9 March 2009

**APPLICATION TO MODIFY PROJECT APPROVAL NO. 08-0049
SYDNEY WATER FACILITY, POTTS HILL RESERVOIRS SITE**

We make this application under Section 75W of the Environmental Planning and Assessment Act 1979 (the Act) on behalf of Brookfield Multiplex. The application is to amend some of the detailed design and layout of the approved project.

North + East Elevations

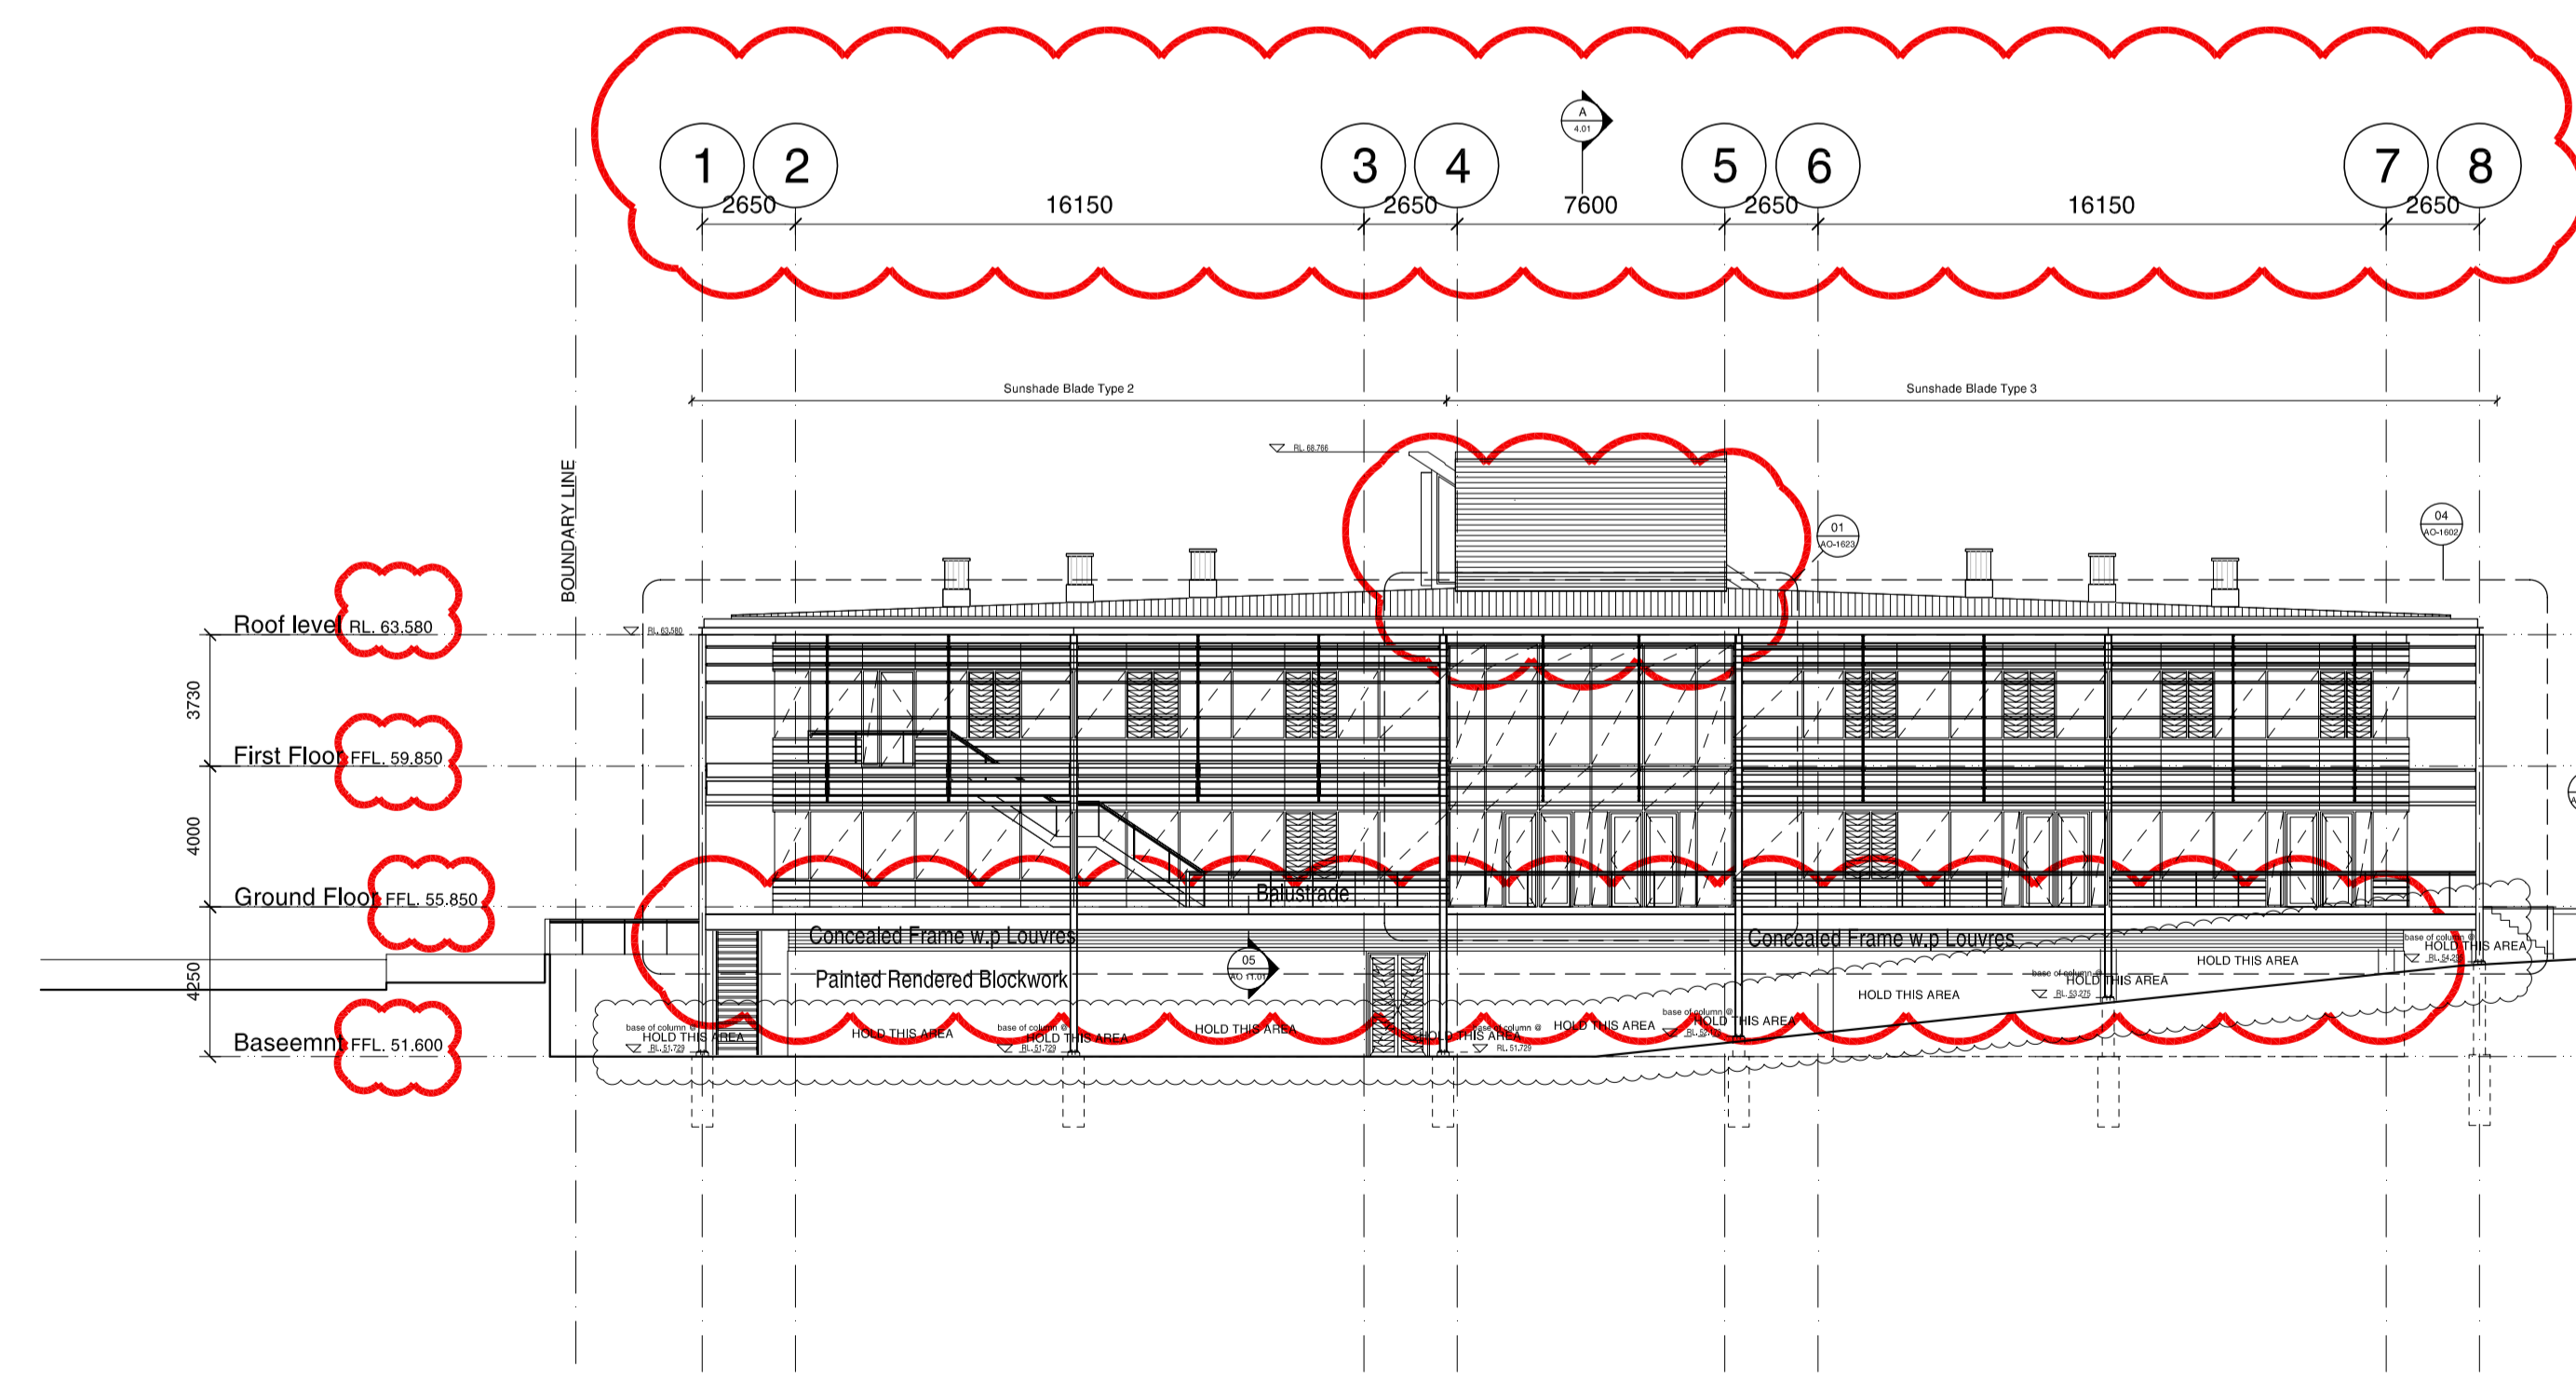
Warehouse/warehouse office	- Warehouse extended north by c. 25m and east/west width increased by 1.2m - Floor levels at warehouse office changed, ramp deleted, lift added - Internal layout of warehouse office amended - Warehouse main roof height increased by 500mm - Precast concrete based added to elevations
Site	- Concrete storage bin layout amended - Above-ground water tanks added at north of site entrance - Truck wash layout amended
Car parking	- Car and truck/trailer layout altered and accessible car spaces included - Number of spaces altered as outlined in following table
Landscaping	Landscaping amended to accommodate layout changes
Stormwater and civil works	More detailed civil works, stormwater and sediment control plans consistent with layout changes and reflecting more detailed construction design

Level 01 Floor Plan

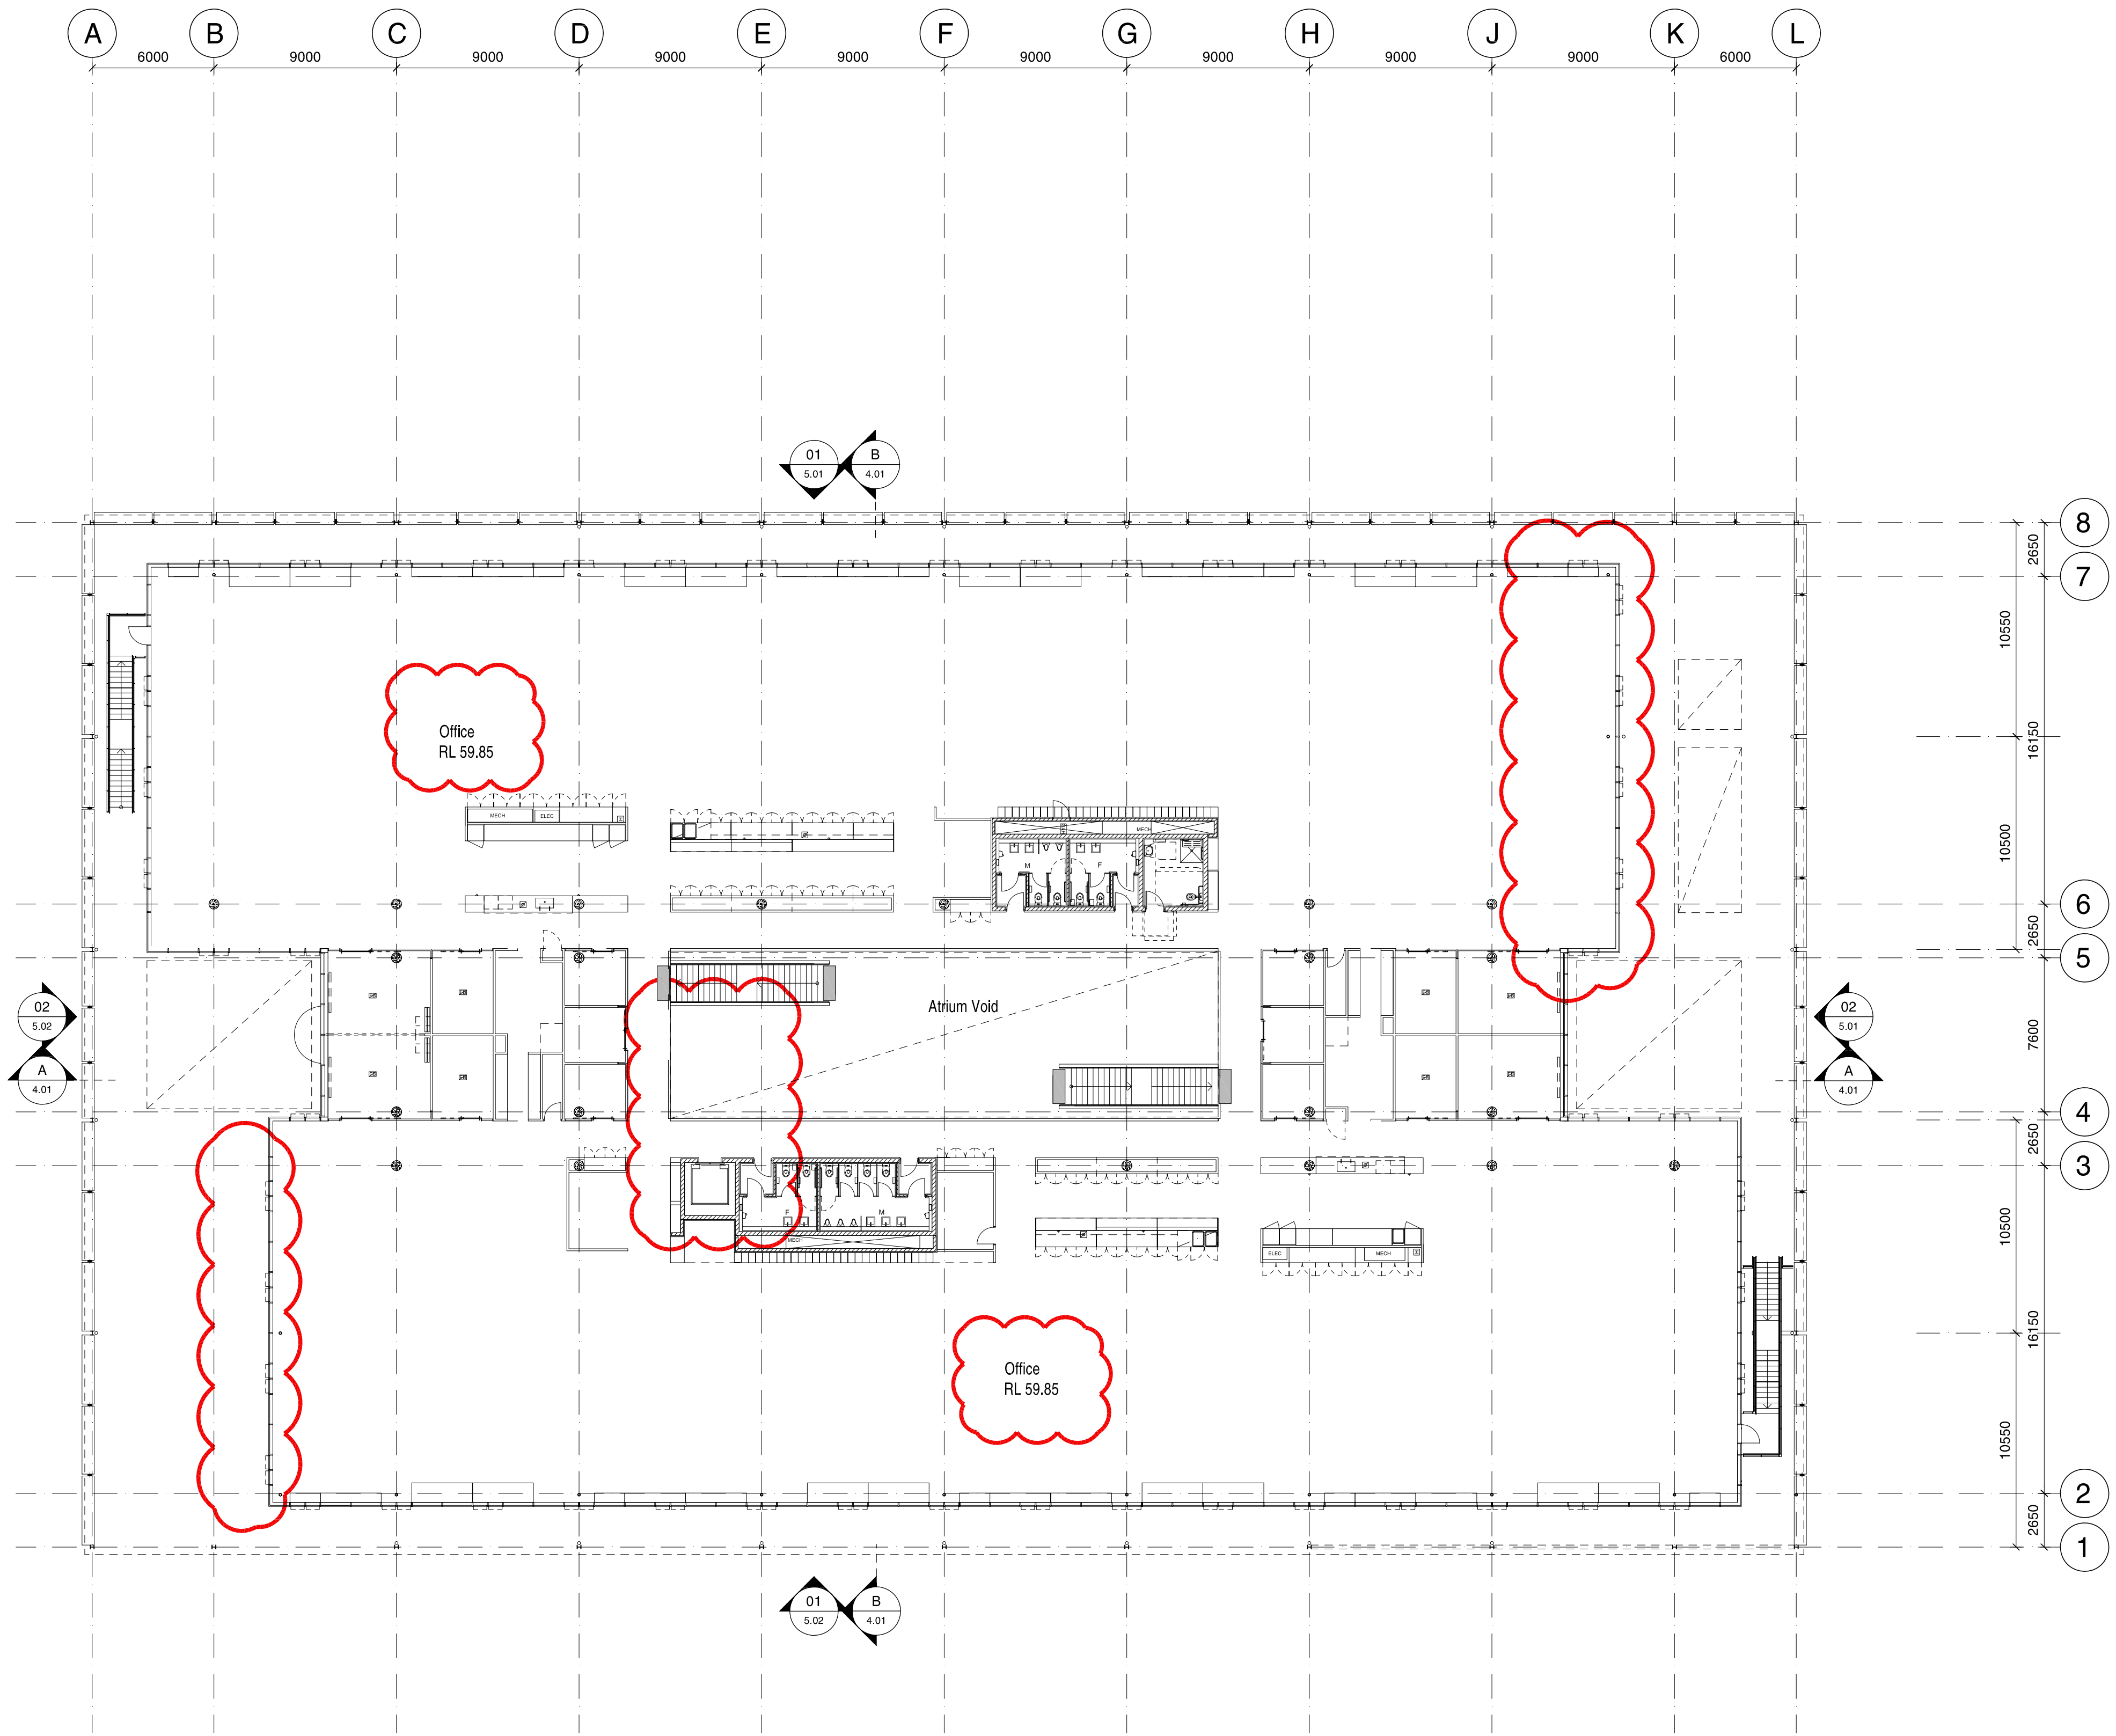
Element	Proposed modifications
Office	• North portion of office extended east by 1.2m and south portion extended west, at ground and level 01 • Enclosed basement added, principally for store rooms, plant rooms, rainwater tanks and the like • North/south dimension reduced • Minor internal layout amendments • Roof design amended and roof level reduced by 515mm
